**M1 Pacific Motorway extension to Raymond Terrace (SSI 7319)
Advice on the Environmental Impact Statement (EIS)**

Thank you for the request for advice from Public Authority Consultation (PAE-24749572), requesting the review by the NSW Environment Protection Authority (EPA) of the Environmental Impact Statement (EIS) for the proposed M1 Pacific Motorway extension to Raymond Terrace (Application SSI-7319).

ATTACHMENT A: EPA COMMENT ON EIS FOR M1 PACIFIC MOTORWAY EXTENSION TO RAYMOND TERRACE (SSI 7319)

Location: L11 - 2264 Pacific Highway,

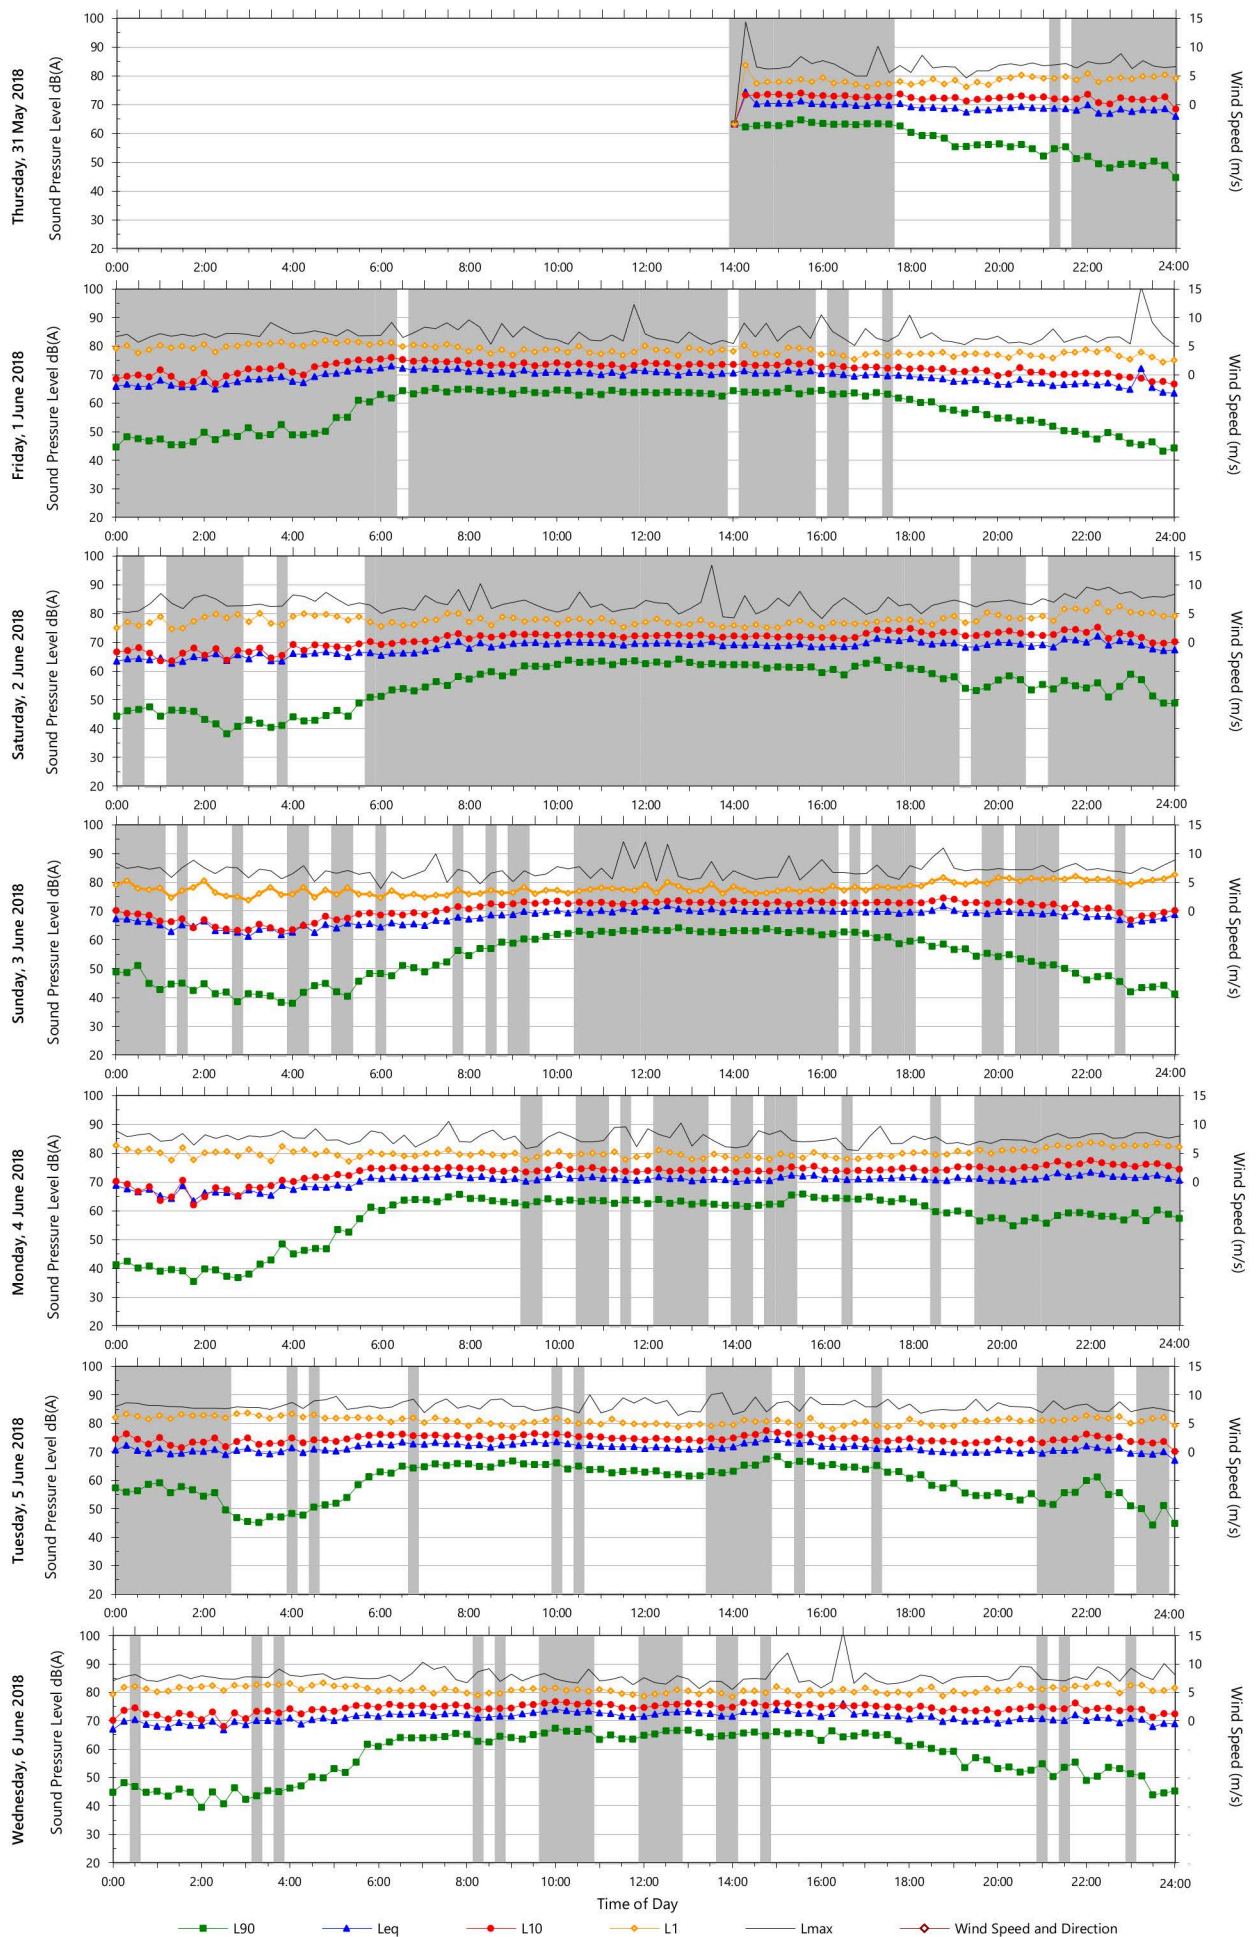
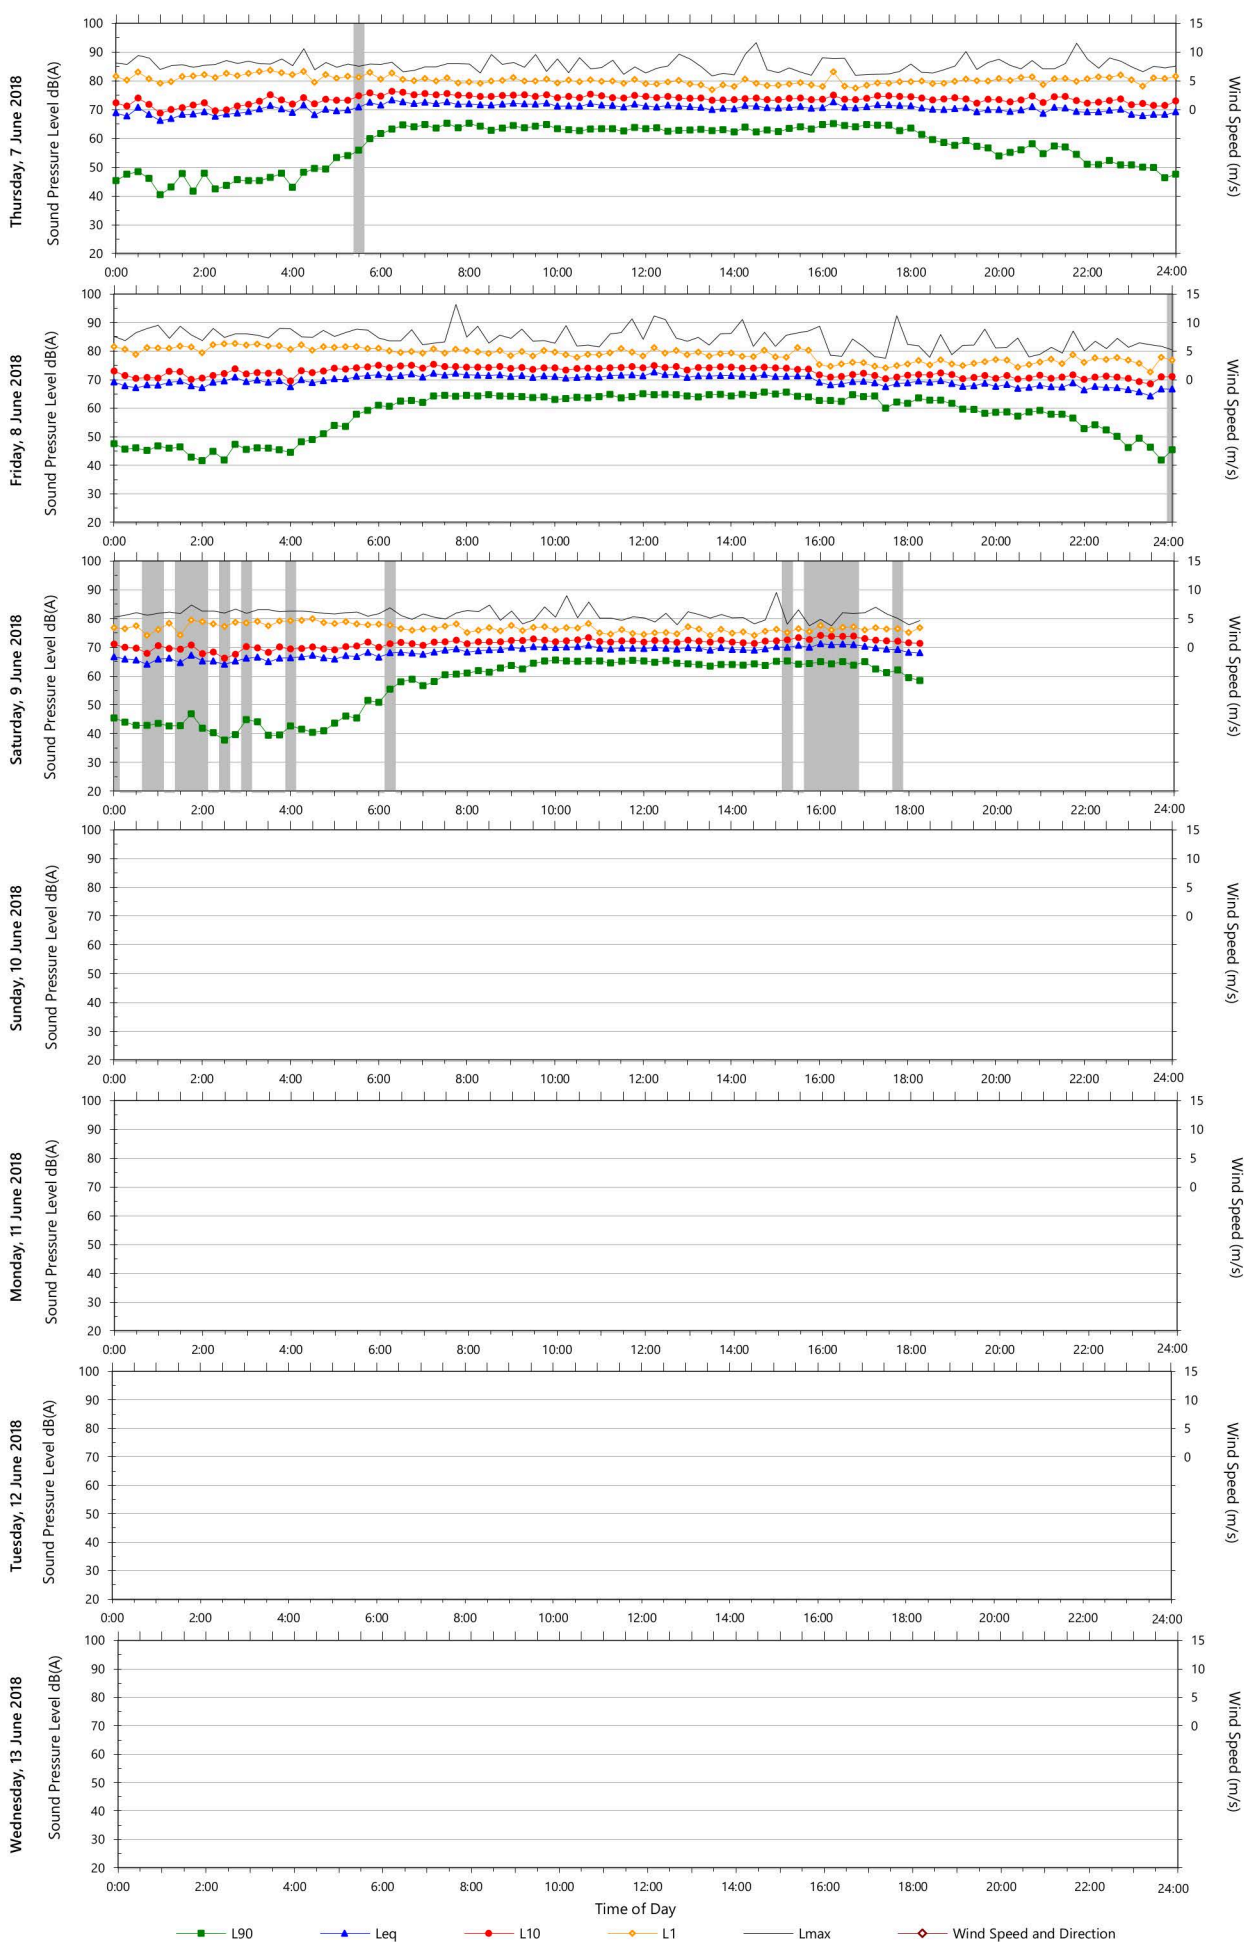
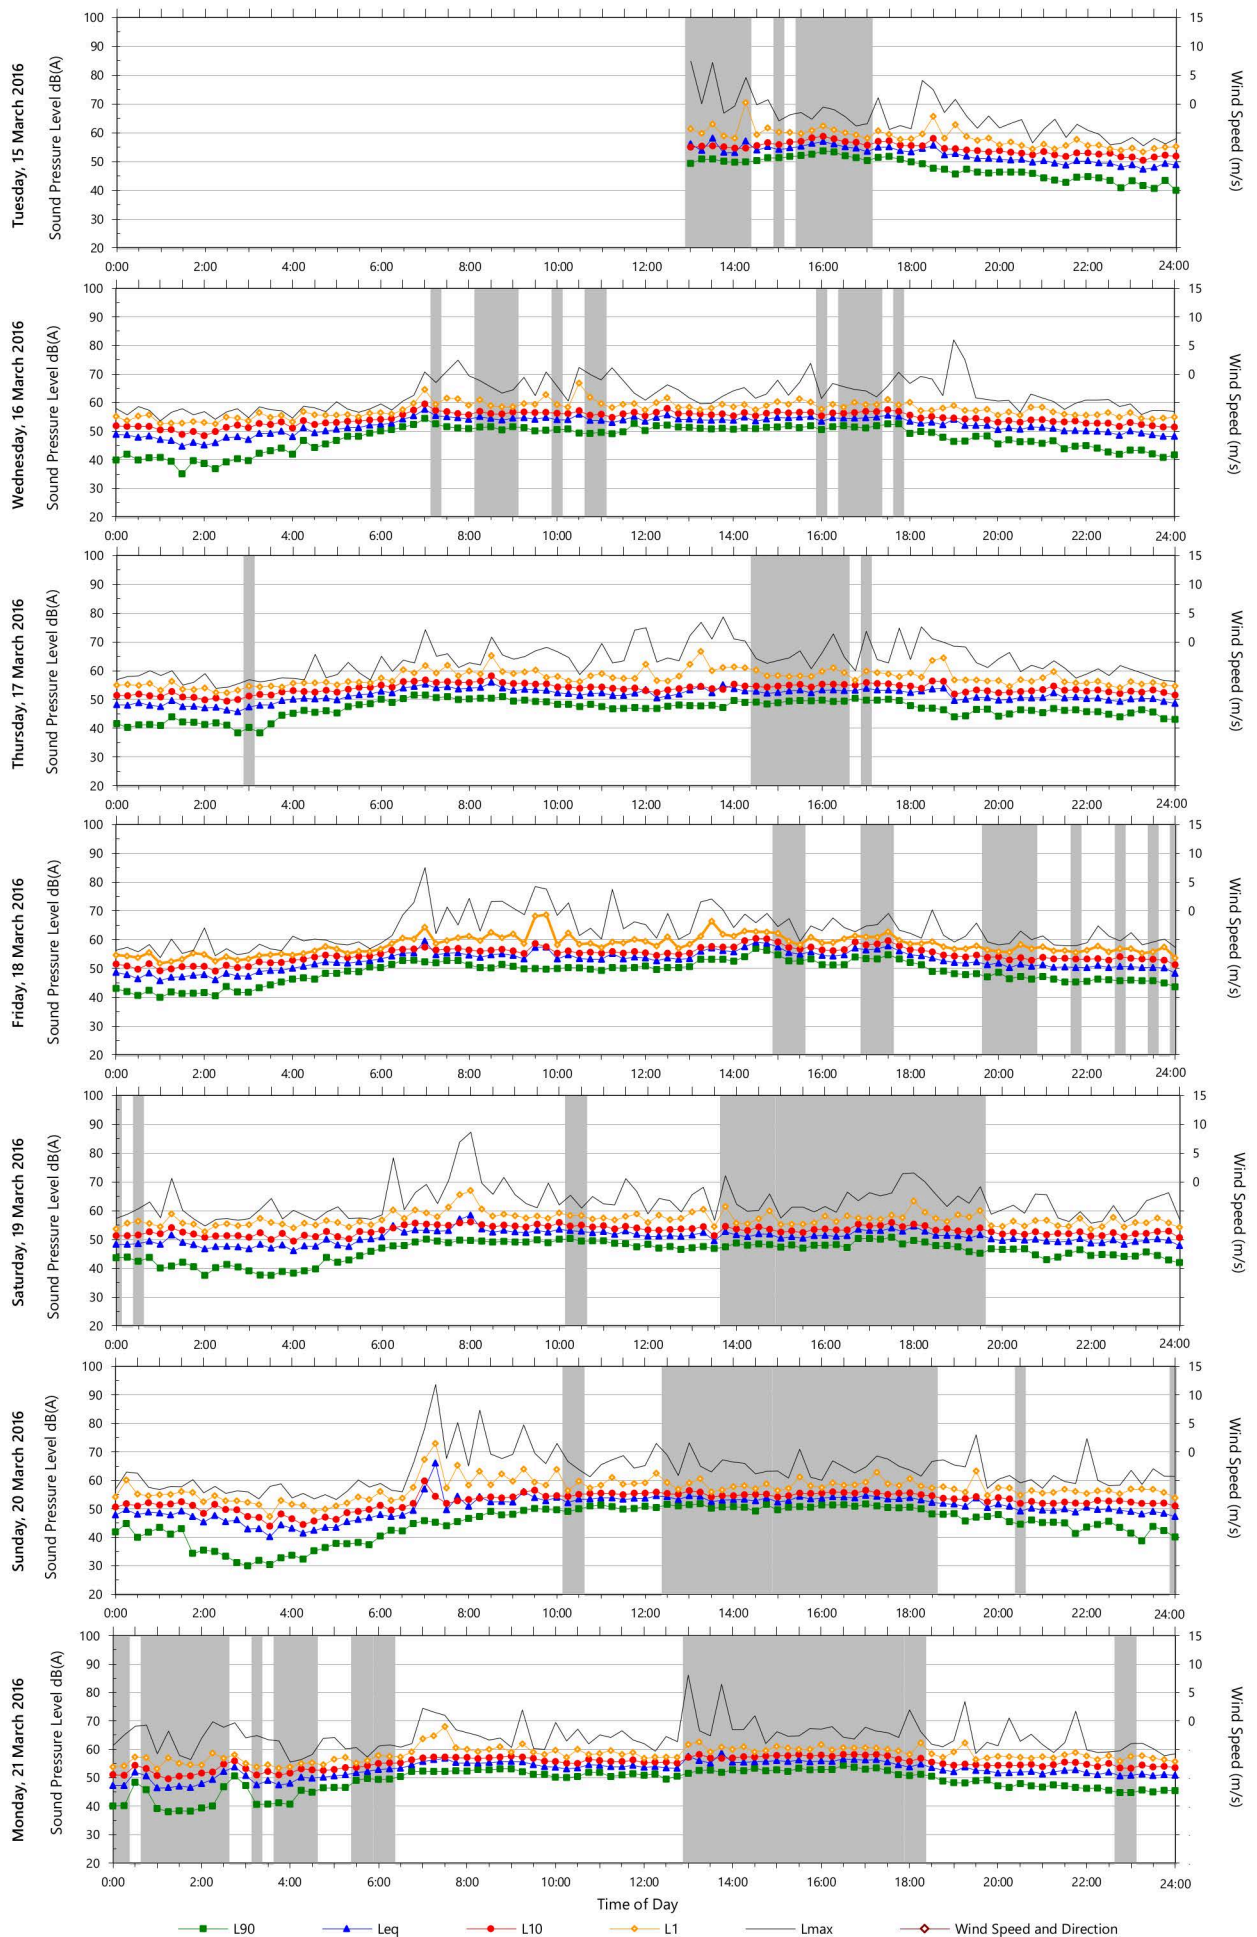
A review of the noise monitoring graphs in NIA Appendix B.2 indicates that further justification for the adequacy of noise monitoring presented or additional information is required.

A significant amount of data appears to have been excluded due to either inclement weather or extraneous noise. The EPA is concerned that the extent of data excluded means that it may not be representative of long term background noise levels, and therefore its suitability to be used to establish reliable noise management levels could be called into question.

Locations L01 to L014 (inclusive) appear to have no more than 5 and in some cases less than 3 valid periods out of the total monitoring duration. Locations L15 to L20 appear to be less affected, however there it is still not clear if sufficient valid data has been presented.

Fact Sheets A and B in the Noise Policy for Industry (NPfI) set out the EPA's requirements for establishing background noise levels. Due to the amount of data excluded, it is currently not clear if these requirements have been satisfied nor if sufficient valid data has been presented in order to establish representative background noise levels.

Noise monitoring was also conducted in 2016 for the purposes of measuring road traffic noise. Due to the amount of data excluded at Locations L13 to L20, further justification is needed that the remaining data, after invalid samples were excluded, provides sufficient amount of data to enable a representative calculation of the traffic noise descriptors.

The proponent reviews the noise monitoring data in the NIA in the context of the monitoring requirements set out in the NPfI and for each location and either:

- Provide a justification and demonstrate that the requirements of the NPfl have been fulfilled; or
- Provide additional data that fulfills the monitoring requirements in the NPfl.

The EPA also recommends that the proponent either:

- Provides justification and demonstrate that the data presented for road traffic noise descriptors is sufficient to be representative; or
- Provides additional valid data.
